Your Ref
P/141/07
 Our Ref
DSD/S/AR/P/2007/141
 Date
30/11/2007
 Contact
 Tel **01634 824103**
 Fax **01634 824179**

1 new dwelling
Land adjacent Cosy nook, Hook Lane, Pagham

Southern Water MapGuide Browser

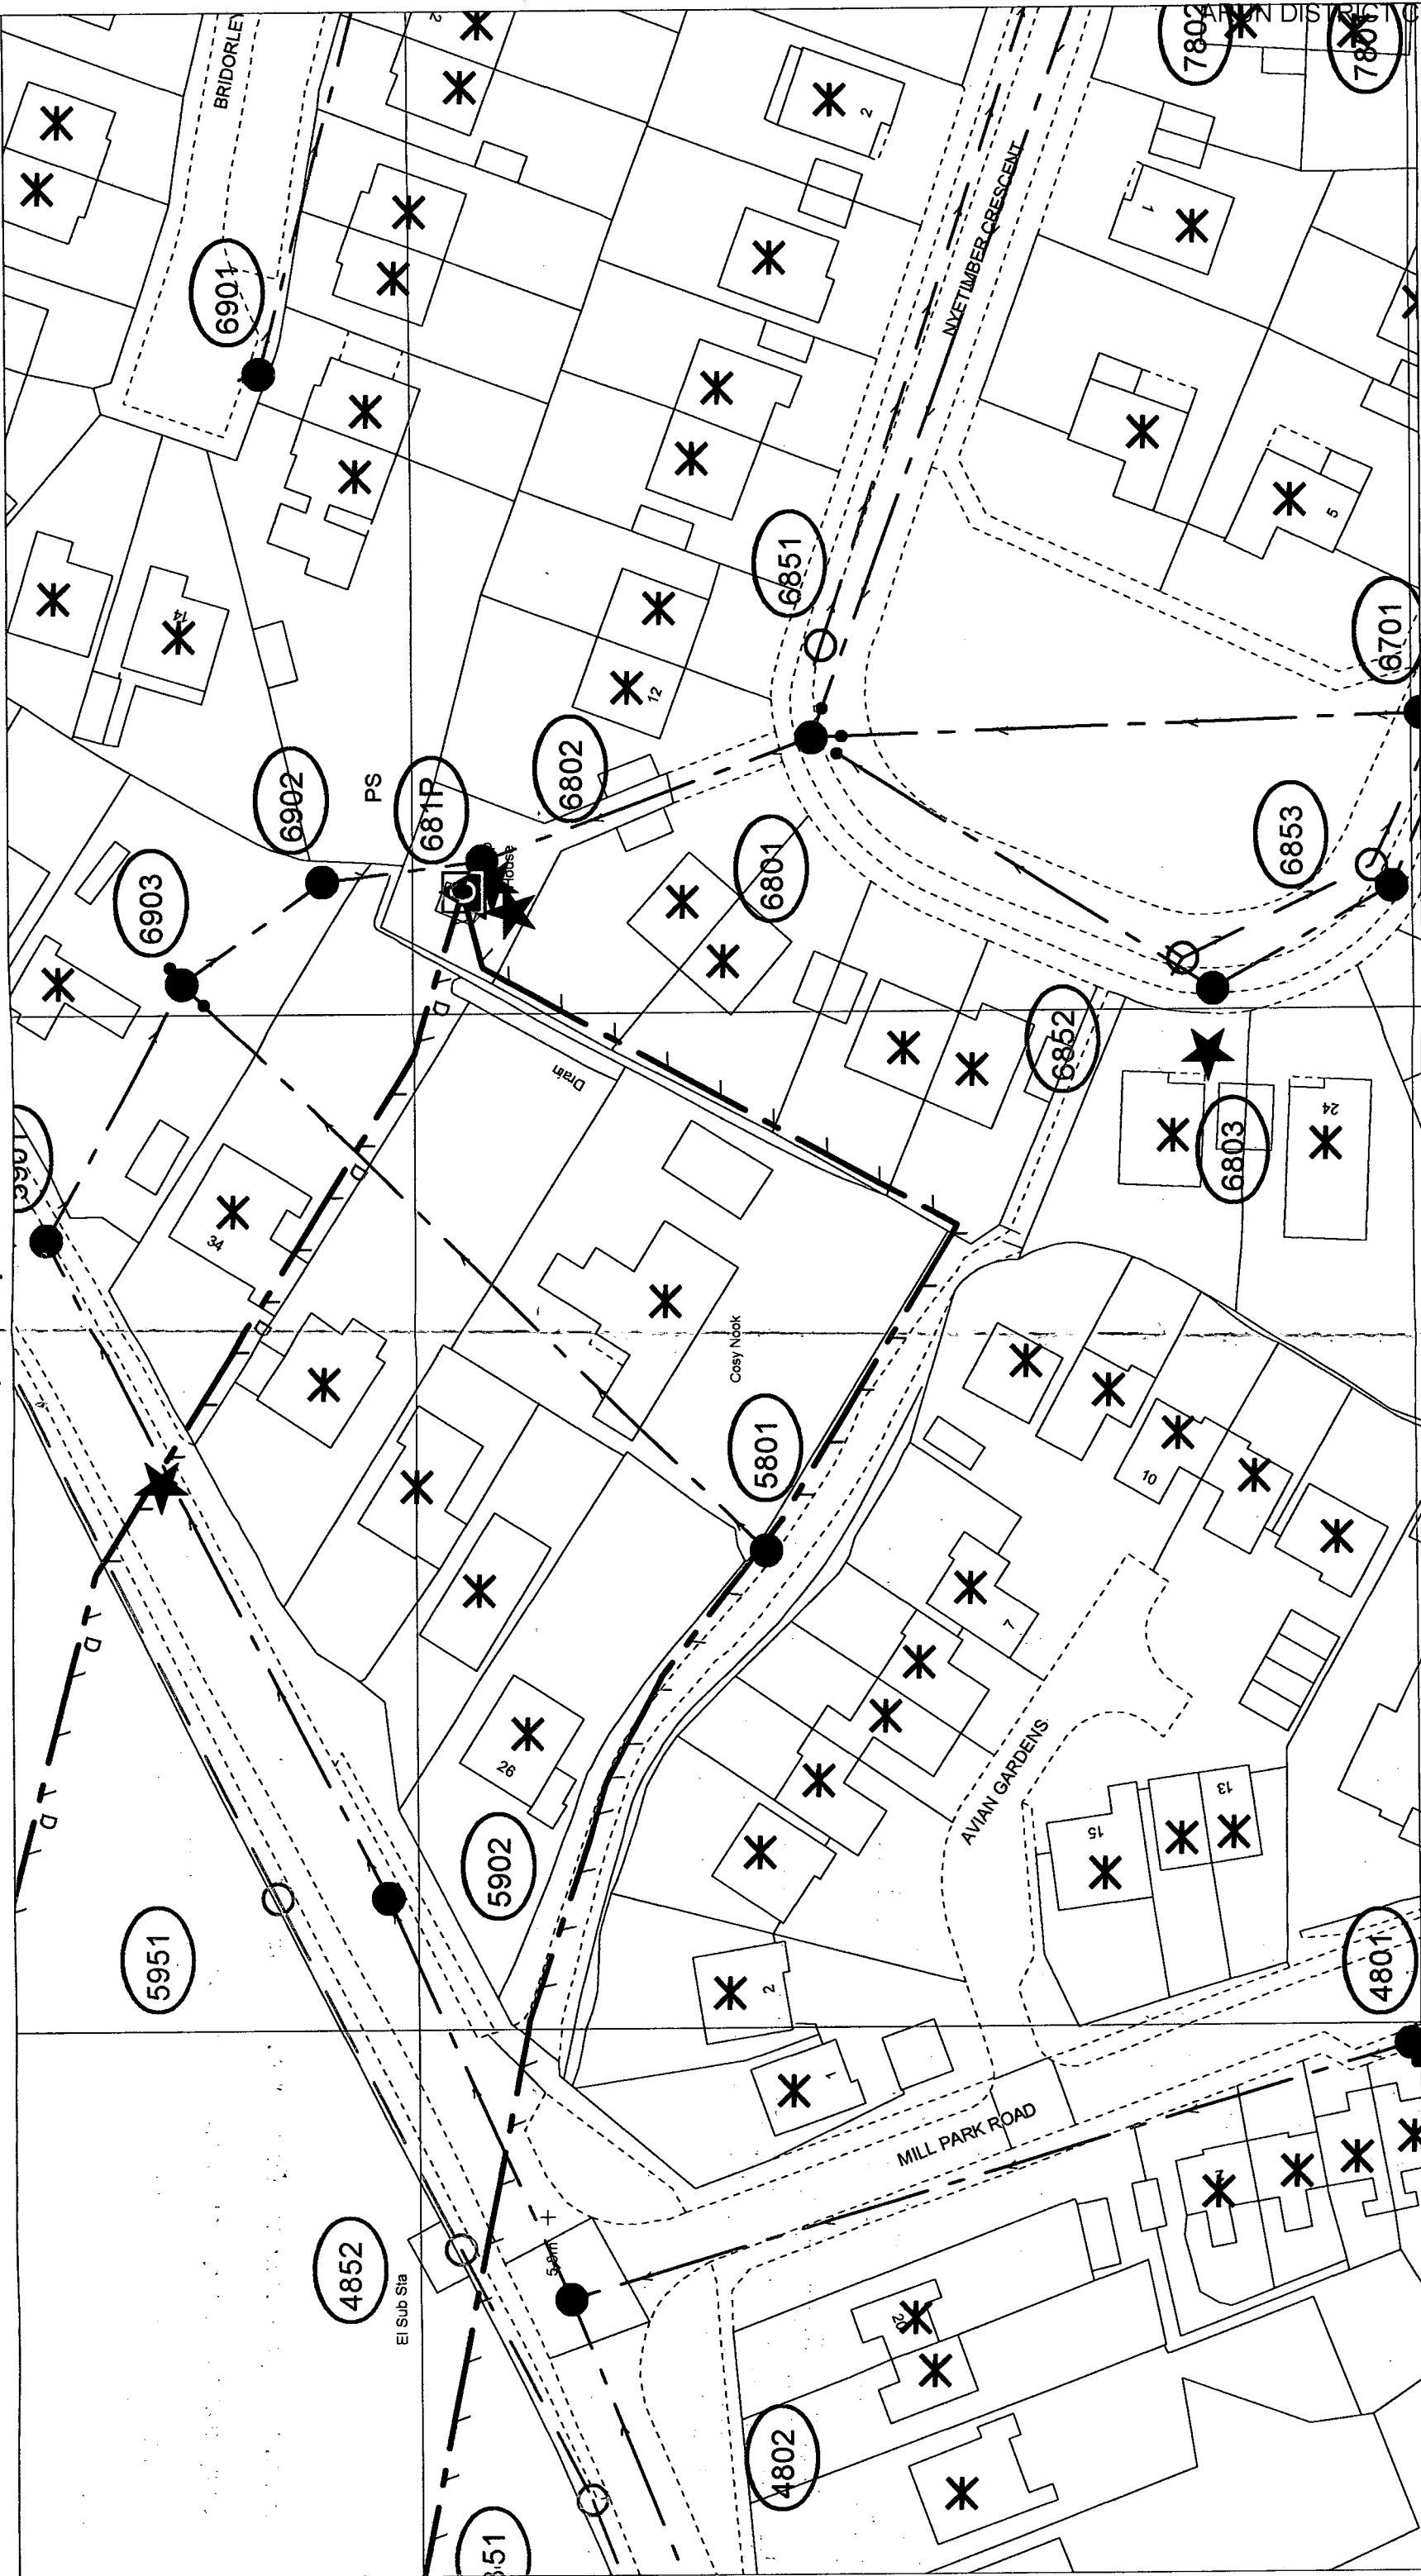
Please find attached a plan of the sewer records showing the approximate position of a public sewer in the vicinity of the site. The exact position of the public sewers must be determined on site by the applicant before the layout of the proposed development is finalised. Please note:

No development or new tree planting should be located within 3 metres either side of the centreline of the public sewer and

All existing infrastructure should be protected during the course of construction works.
